SSD7881 (DA2a)

Supplementary Response to issues raised by City of Sydney (CoS) submission

2 FUNCTION ROOM LATERAL WALL - DEMOLITION ELEVATION EAST 1:50

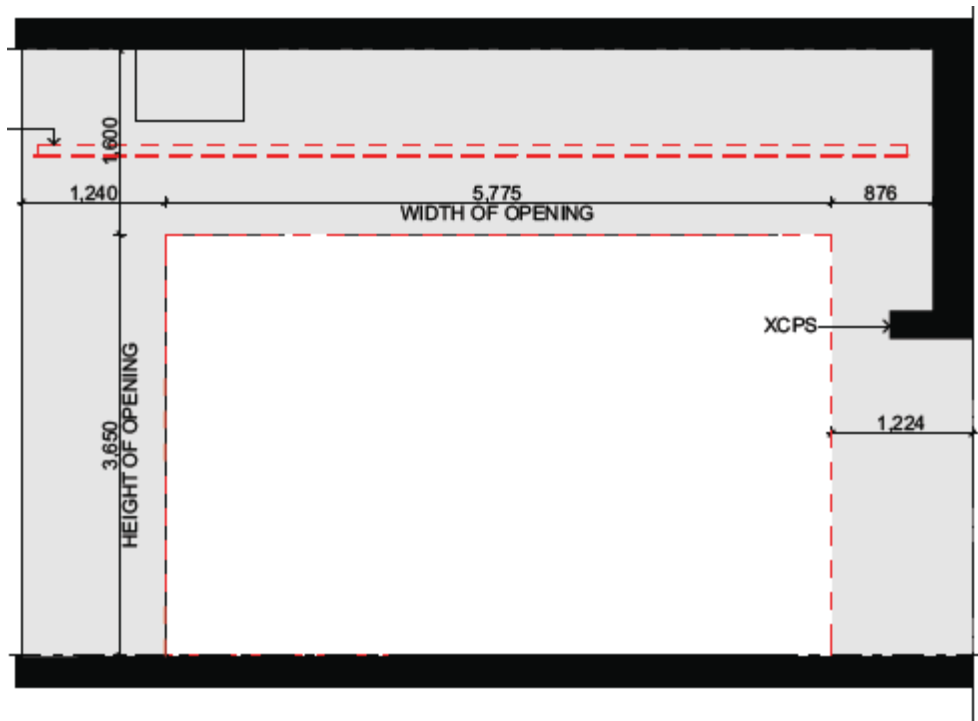
Following the meeting on the 19th January 2017 the City re-iterated that proposed irreversible internal changes and the demolition of a portion of the curved corridor to form the Function Centre should be carefully reconsidered and limited to that which is absolutely necessary.

- There is no reference in the Utzon Design Principals that directly contradicts the use of the space as a function centre instead of a restaurant.
- The removal of the significant fabric was noted in the Heritage Impact Statement. However, the Opera House considers that the proposed openings outlined in Figure 1 below are justified, and absolutely necessary.

The structural opening proposed by the Sydney Opera House is 5775mm (w) x 3650mm (h). This differs to the information provided in the original EIS as refinement of the structural analysis has meant that more of the wall can be retained. The size of these openings has also been workshopped with architects, TZG, and the Eminent Architects Panel, as detailed by TZG in their attached letter. The size of the proposed openings are considered to be the right balance between preserving heritage structure and introducing functionality & connectivity between the spaces.
